Ribble Valley Borough Council
Development Control

Application no: App3/2019/0463

Address: Land at Sawley Road, Chatburn

Proposal: Erection of 6 Polytunnels and construction of car park

Proposed Site Plan - 1:500

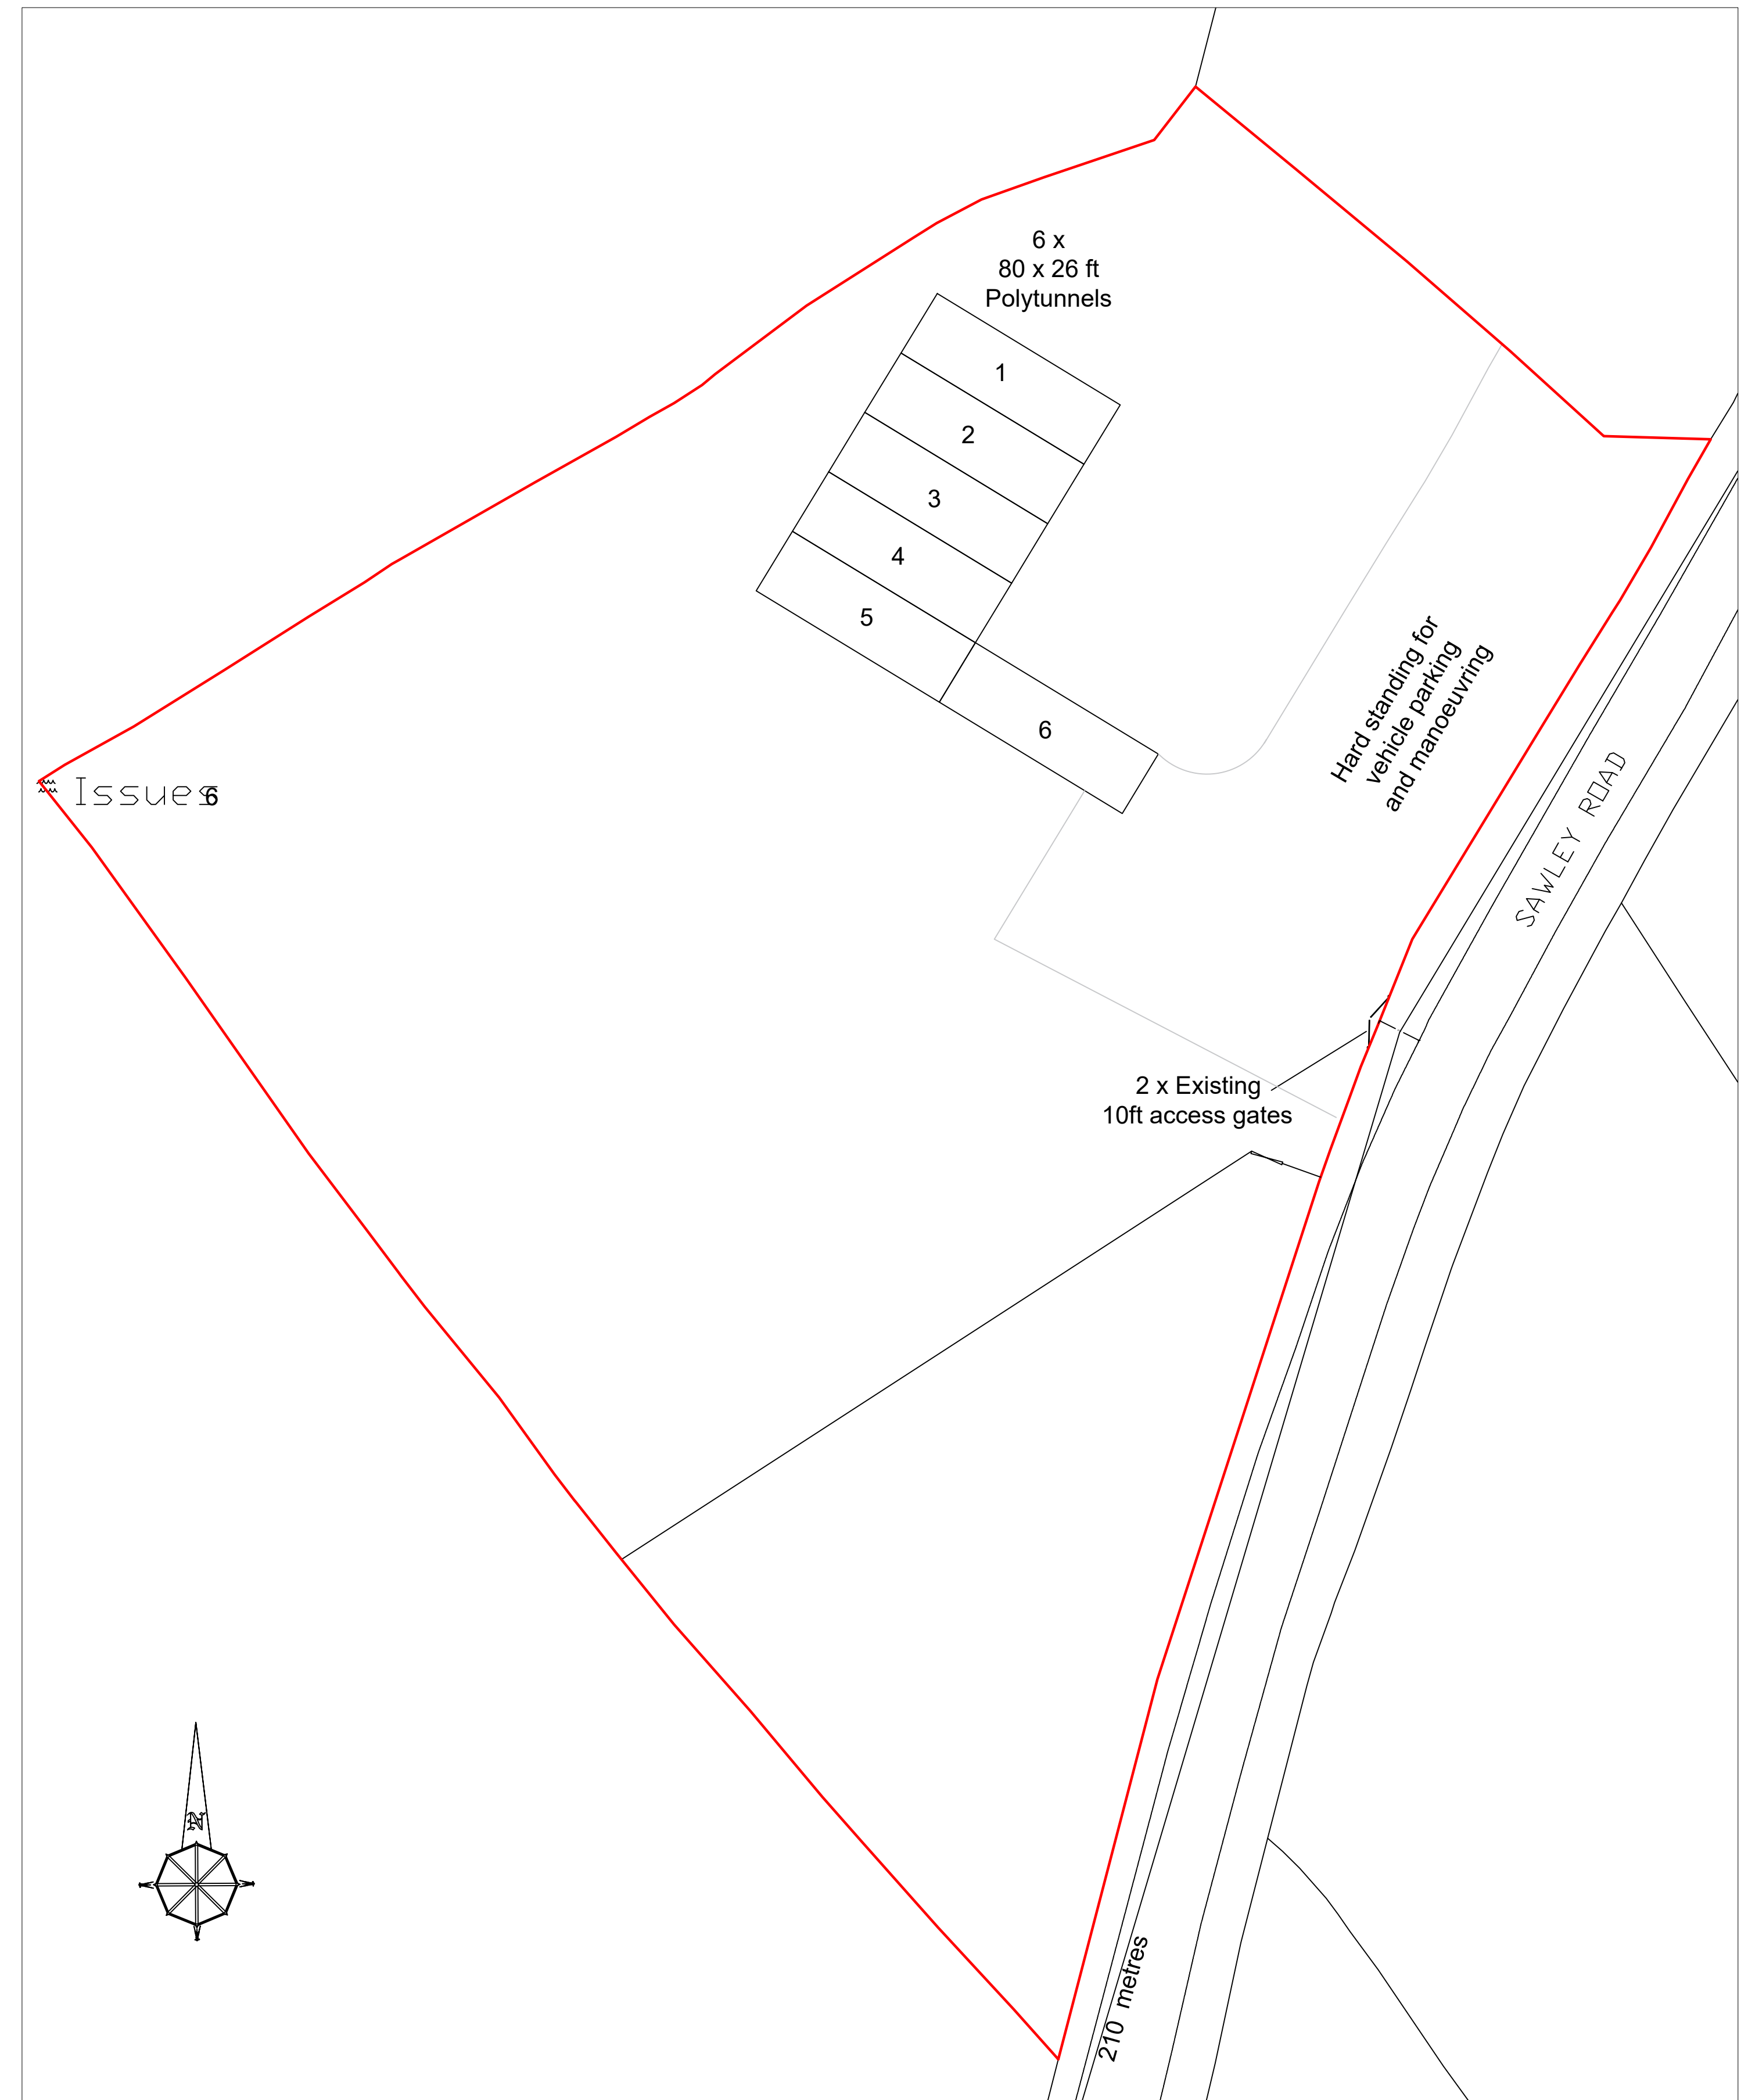
However I would envisage an increase in movements to / from the existing access and would therefore require the access to be appropriately surfaced to prevent loose material being drawn onto the carriageway, therefore should your council be minded to approve this application I would request that the following condition be attached to any permission that may be granted

1 Before the access is used for vehicular purposes, that part of the access extending from the highway boundary for a minimum distance of 5m into the site shall be appropriately paved in tarmacadam, concrete, block pavements, or other approved materials. Reason: To prevent loose surface material from being carried on to the public highway thus causing a potential source of danger to other road users.
